A1 in Northumberland: Morpeth to Ellingham

Scheme Number: TR010059

7.6A Statement of Common Ground with Northumberland County Council

**Statement of Common Ground with
Northumberland County Council**

Drawing Title: Figure 7.12 - Coronation Avenue SHEET 6 OF 7

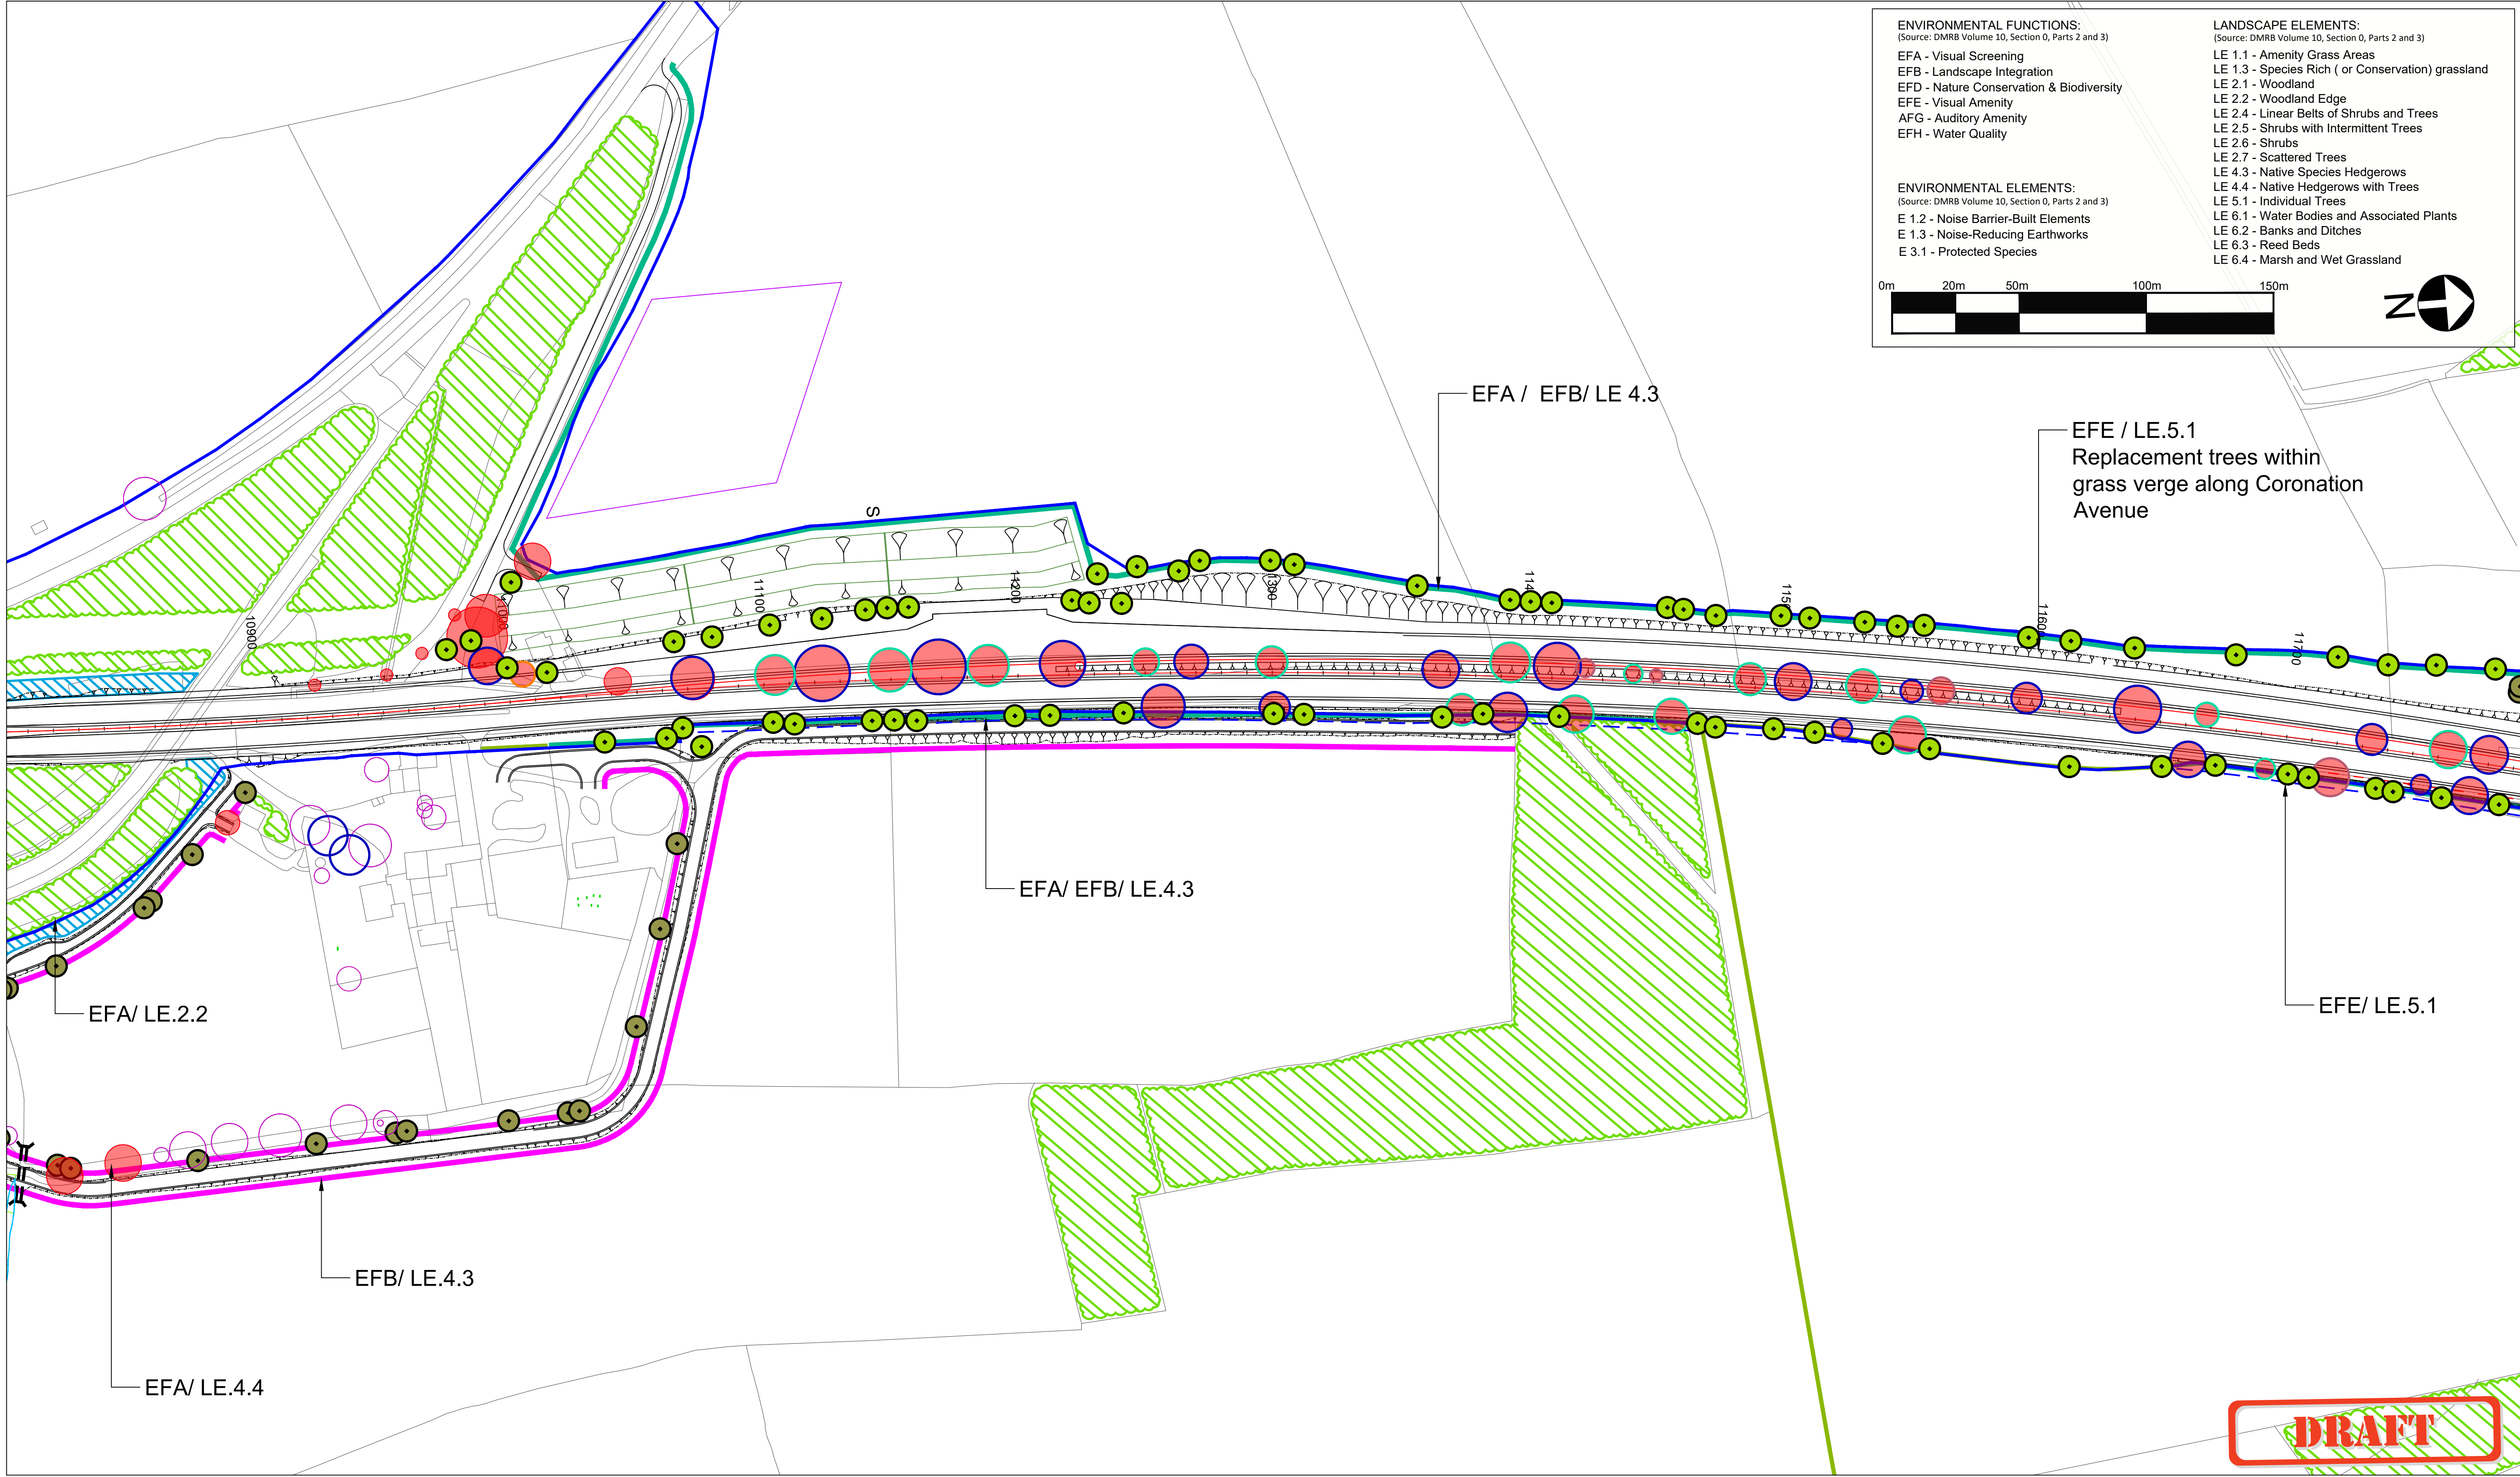
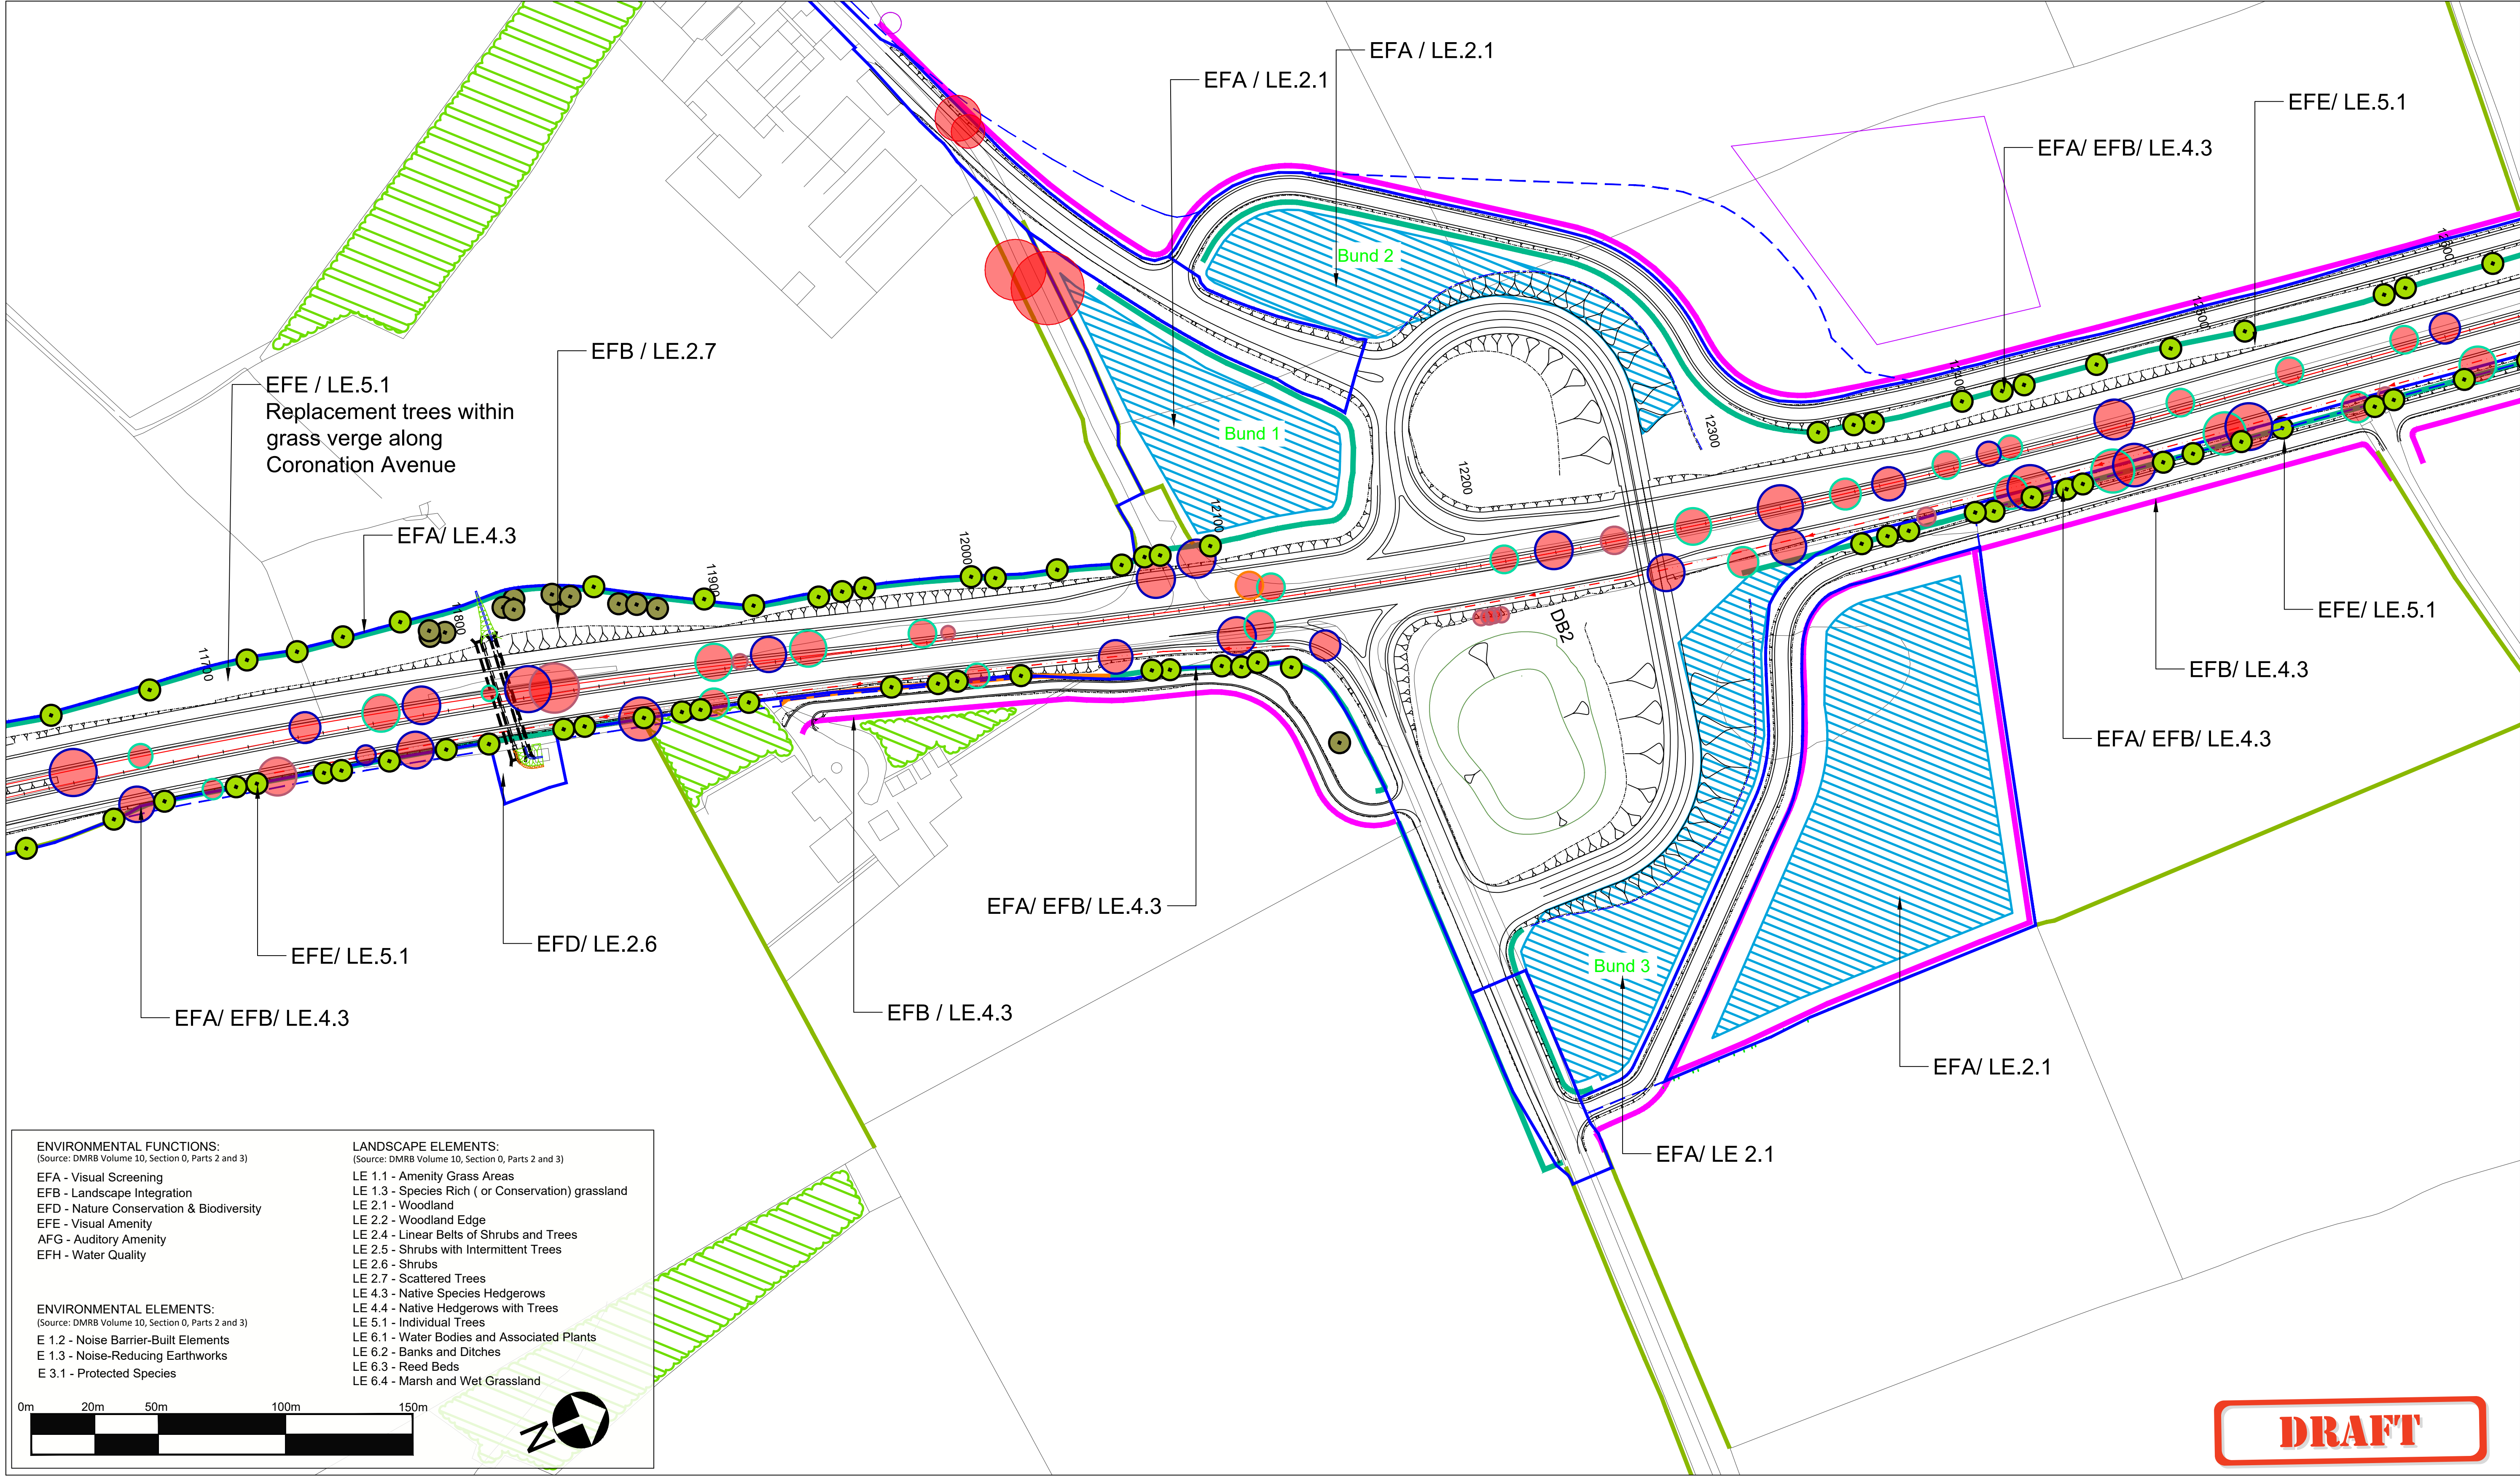
Date	Form of Correspondence	Key Topics Discussed and Key Outcomes
6/1/21	Email exchange with Mary Fisher, and Andy Williams (on behalf of the Applicant)	Key Topic Email exchange regarding the design of the Coronation Avenue (number, spacings and frequency). Reference to further discussion with NCC tree officer to also get feedback. Key Outcome Email received from NCC confirming that they are in agreement with the proposed replacement strategy for the Coronation Avenue, as per Appendix LV.2 to Written Question LV.1.8 at Deadline 1 [REP1-032].
07/01/21	Call between NCC and drainage specialist.	Key Topic and Outcome Follow up call to discuss surface water drainage strategy for the Scheme.
14/01/21	Meeting with NCC and the Applicant	Detailed discussion around issues identified with the Rights of Way and Access Plans and DCO Schedules. Key Topic NCC stated that it was unclear from the DCO plans which roads are to be adopted and which are not. NCC also requested clarification as to the extents of stopping up of the existing A1 at the southern end of the detrunking section, at Priest's Bridge. NCC believe stopping up of highway should continue further south than is shown on the Rights of Way and Access Plans. NCC stated that the extent of soft estate to be adopted is unclear, with respect to earthworks, verge, landscaping and detention basins. Key Outcome A scheme overview plan showing the extent of roads to be adopted was produced and issued to NCC on 08/02/21. Extents of stopping up of the existing A1 at the southern end of the detrunking section, at Priest's Bridge, amended as per NCC's suggestion. Updated Rights of Way and Access Plans issued at Deadline 02. [REP2-003]. The Applicant is unable to confirm exact limits of soft estate to be adopted at present. Such details are subject to detailed design, with the exception of the detention basins for adoption which can and will be confirmed.
